Re: Submission on Cabramatta Loop Project (SSI 9186)

Thank you for the opportunity to provide a submission on the above State Significant Infrastructure (SSI) project application. The project will comprise the construction and operation of a passing loop on the Southern Sydney Freight Line (SSFL). This is to enable freight trains, up to 1,300 metres long to pass each other and to travel in either direction.

Figure 6.1d The project

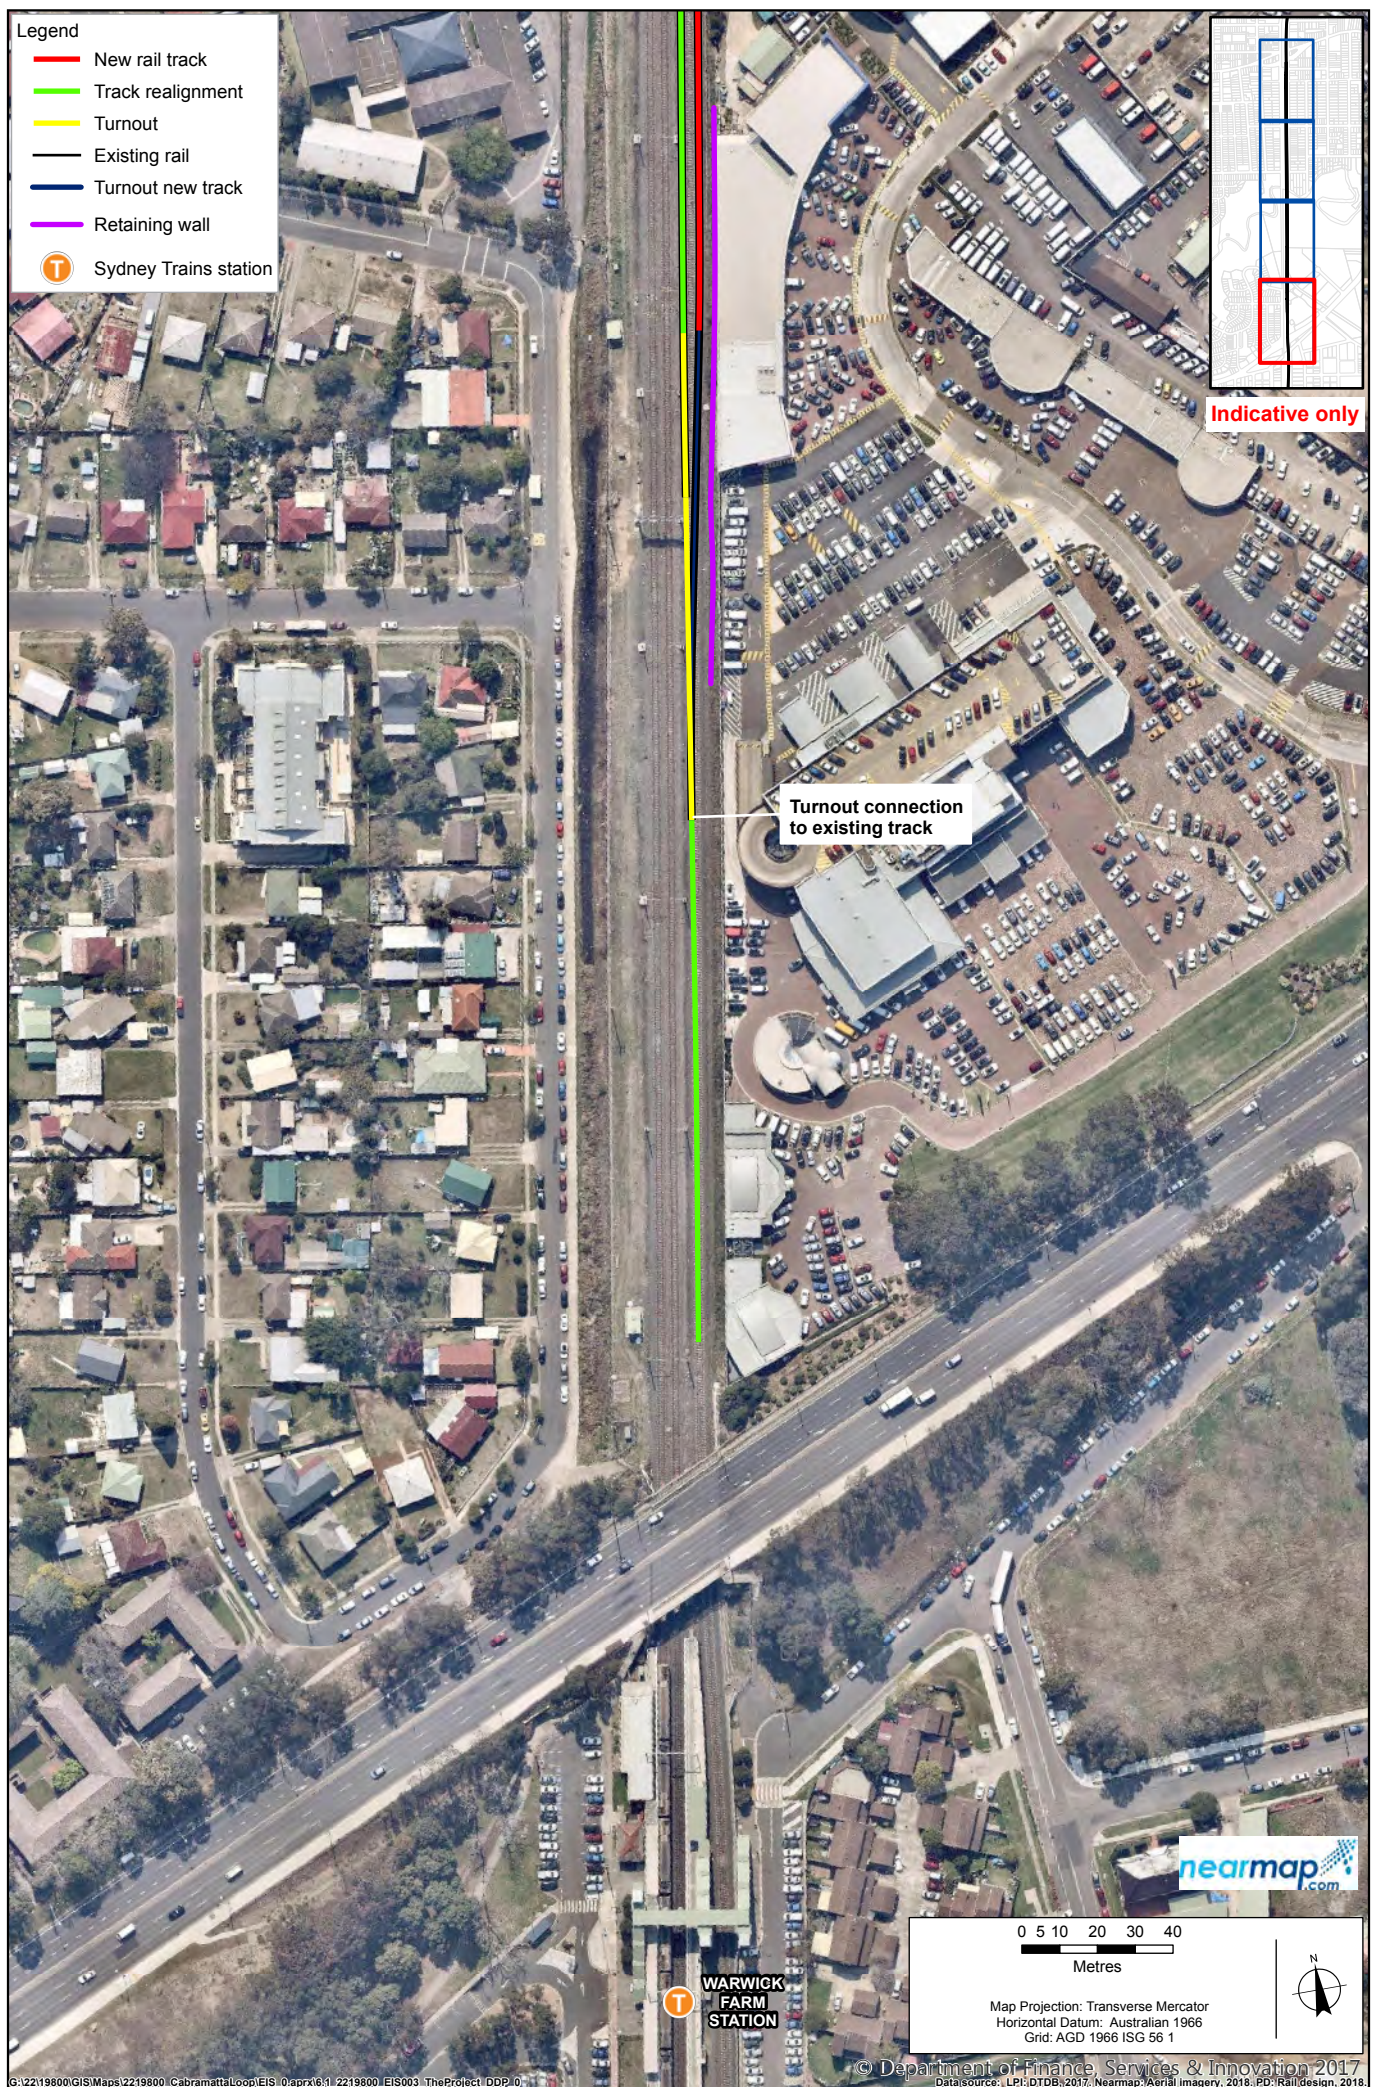
The project work site 'C3' proposed to be located within Jacquie Osmond Reserve, will impact 3 of the 12 softball diamonds available for use by the Southern Districts Softball Association. This will affect seasonal and event usage of these fields. The proposed permanent acquisition of a 5m strip of the reserve to the eastern side of the rail corridor will impact the softball diamond safety fencing, synthetic grass batting squares and the overall diamond dimensions. Pushing the three fields eastward will have a flow-on effect on the dimensions of remaining diamonds.

Removal of the existing shared path over Cabramatta Creek will require construction of a suitable replacement, which maintains connectivity between Station Street and Broomfield Street prior to the existing bridge being removed. Vehicular access to Jacquie Osmond Reserve will also need to be maintained at all times.
